Airly Mine Panel and Pillar Extraction Plan – Modification 2

Centennial Airly is seeking a modification (Modification 2) to the approved Mt Airly Panel and Pillar Zone Extraction Plan (**Extraction Plan**) for miniwall panels MW10 – MW12. The extraction of miniwall panels MW02 - MW05 were originally approved by the Secretary of the Department of Planning on 31 May 2019 with an extended approval for extraction of miniwall panels MW02 – MW15 granted on 25 June 2019. The Extraction Plan modification includes a modification to the pillar design for miniwall panels MW10 – MW11 and change in the approved extraction area to facilitate the return of vertical subsidence levels to <125 millimetres as required by the Airly Mine Extension Project development consent (**SSD 5581**).

AIRLY COLLIERY- ML1331
EXTRACTION PLAN - MINI WALL EXTRACTION
MW2-15 MODIFICATION 2- MW11-12
PLAN 8- Extraction Plan Area

DRG. No. AM02488

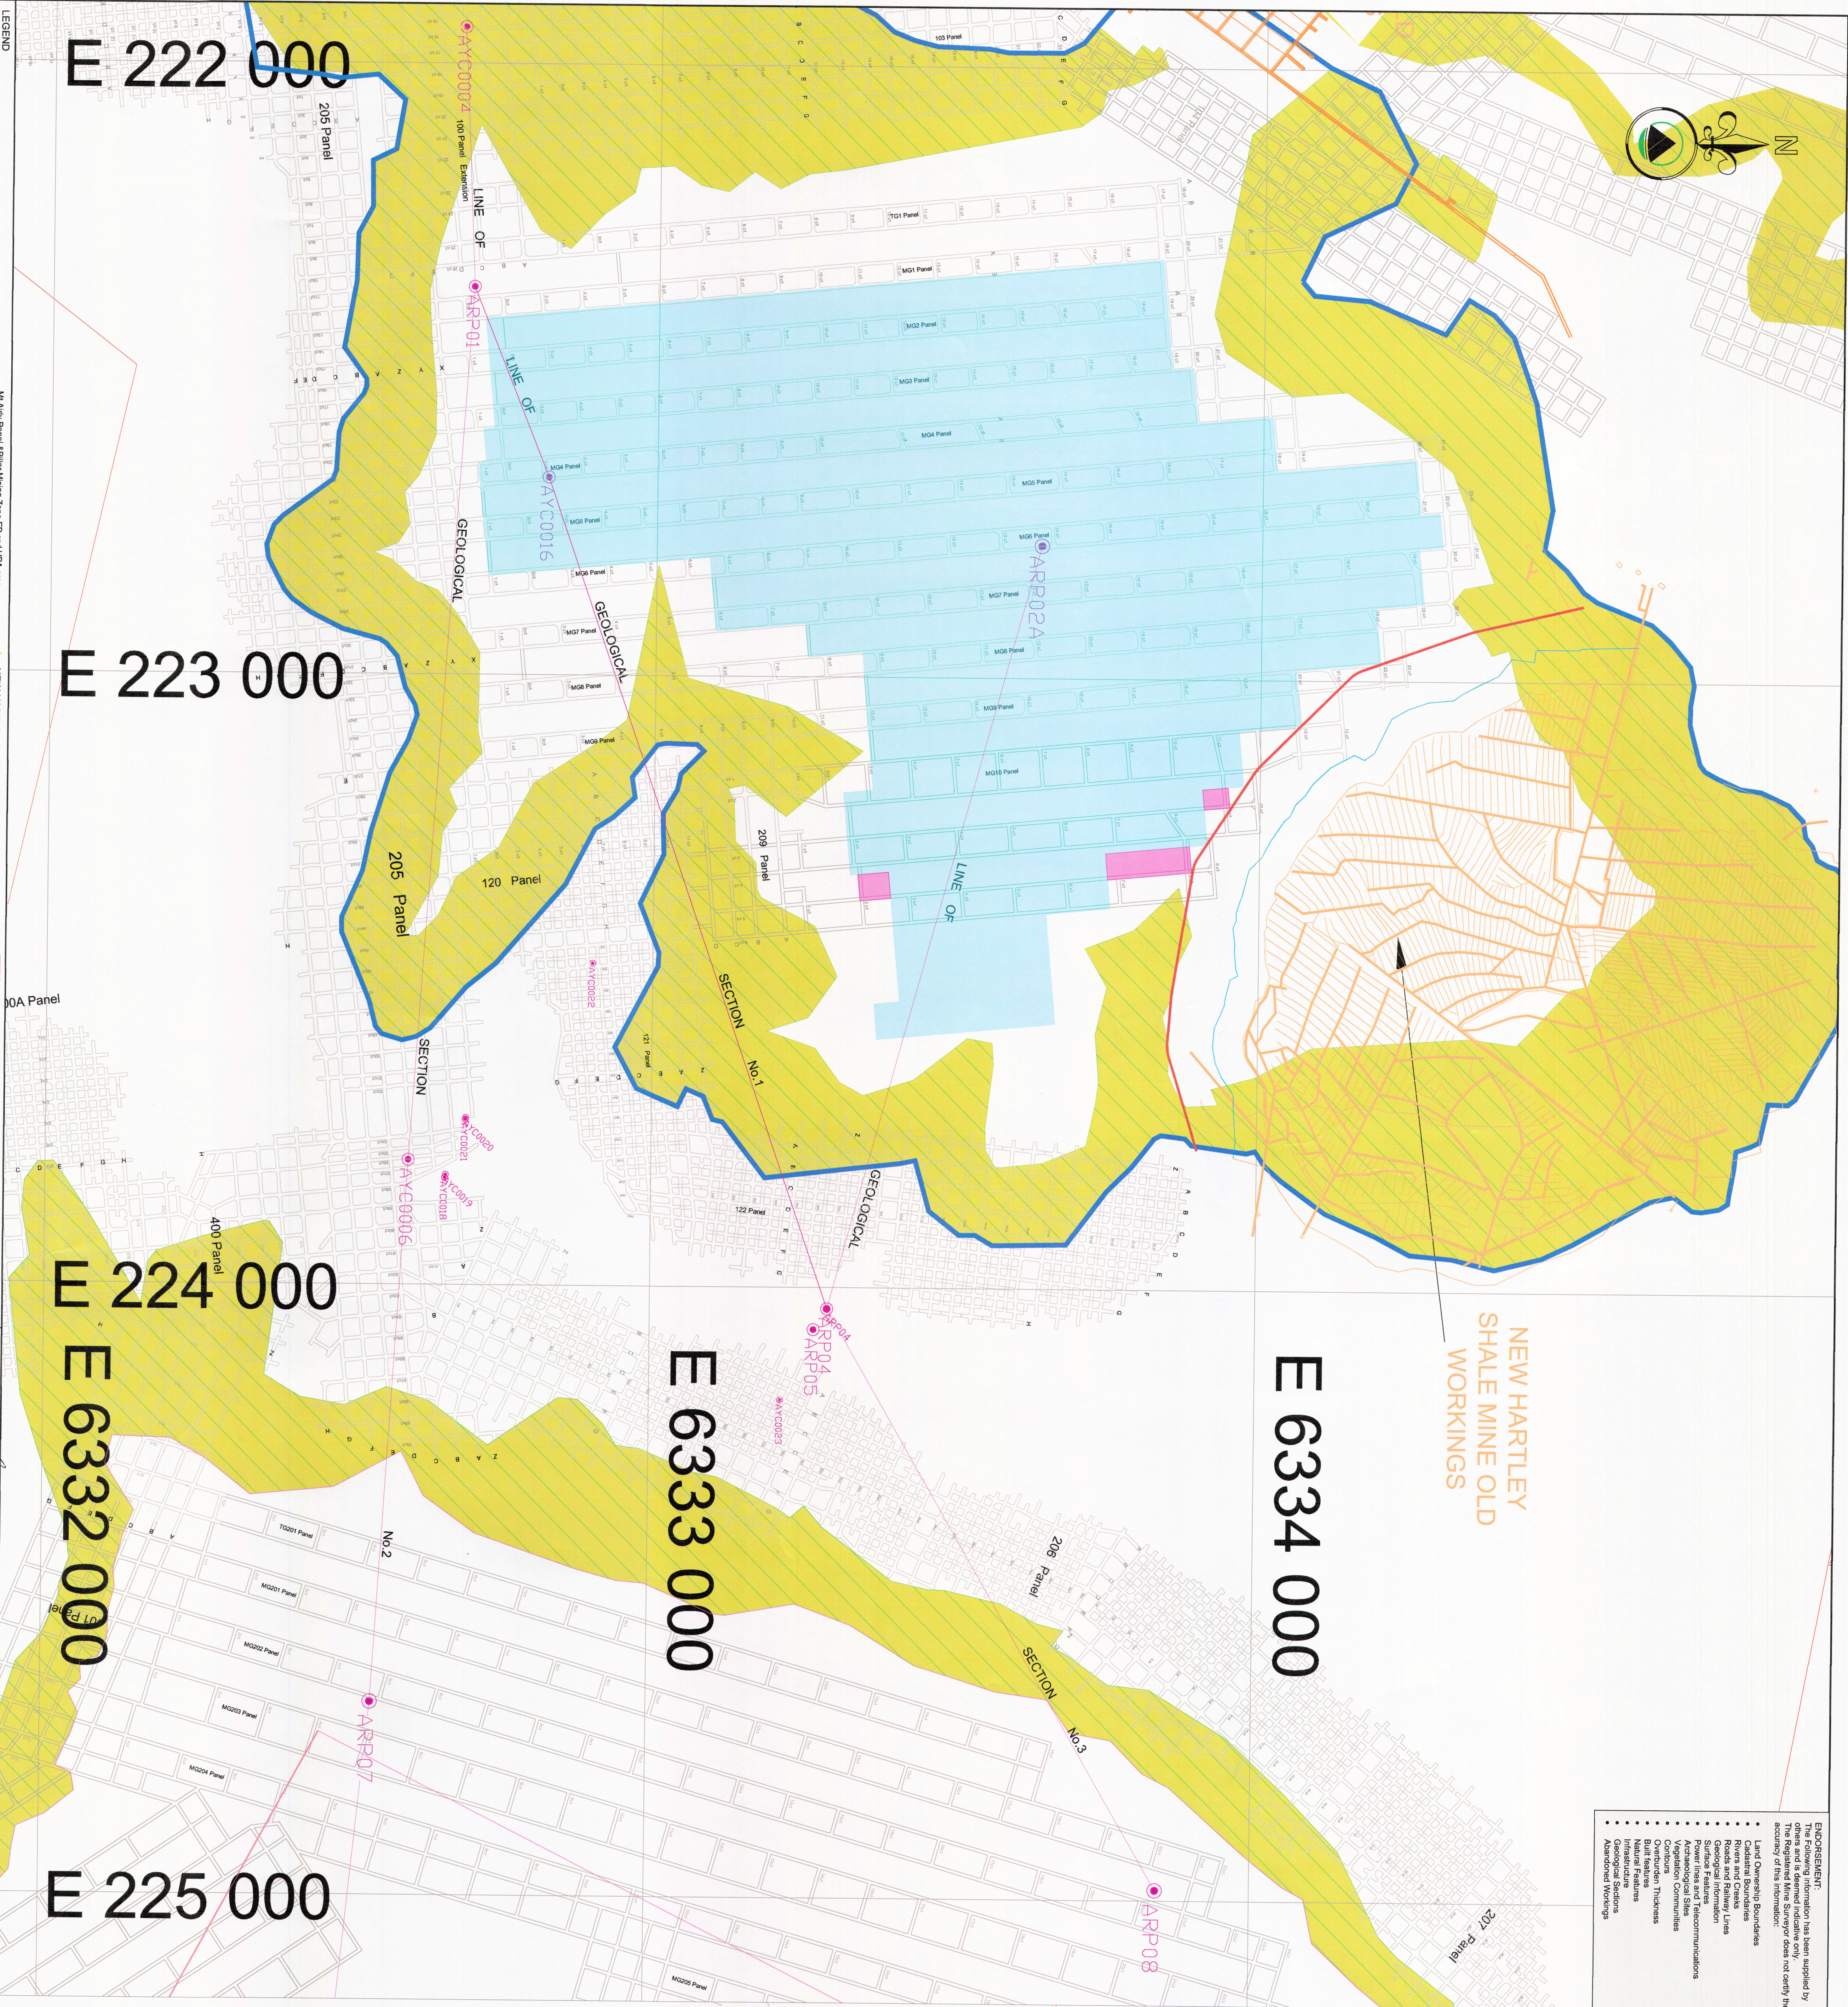
To bring subsidence back to within the EIS limit of 125 millimetres as soon as possible, investigations by SCT recommended an increase in the maingate 10 chain pillar size to form a barrier pillar followed by an increase to the regular chain pillar width for subsequent chain pillars. A number of scenarios were modelled which showed similar results. A 60 metre (solid) chain pillar width in maingate 10, followed by chain pillars in MG11 and MG12 of 40 metre (solid) width has been identified as the optimal mine design that would result in subsidence being reduced to less than 125 millimetres by the tailgate goaf edge of miniwall panel MW11. Detailed subsidence predictions for this mine design are presented in the SCT report attached as a supporting document to this Extraction Plan modification application.

SCT also recommended not mining more than miniwall panels MW11 and MW12 due to the likelihood of some strata failure occurring with wider spans even with the 40 metre chain pillars.

The revised mine design for the remainder of mining within the Mt Airly Panel and Pillar Zone is presented in attached figure (**AM02488**).

This Extraction Plan modification seeks a change in the mine design for miniwall panels MW10 - MW12 which are required to ensure vertical subsidence levels remain below 125 millimetres for the yet to be developed miniwall panels MW11 and MW12. The change in mine design results in minor changes to approved Extraction Area as presented in Figure **AM02488**. No further mining beyond miniwall panel MW12 is proposed under Mt Airly.
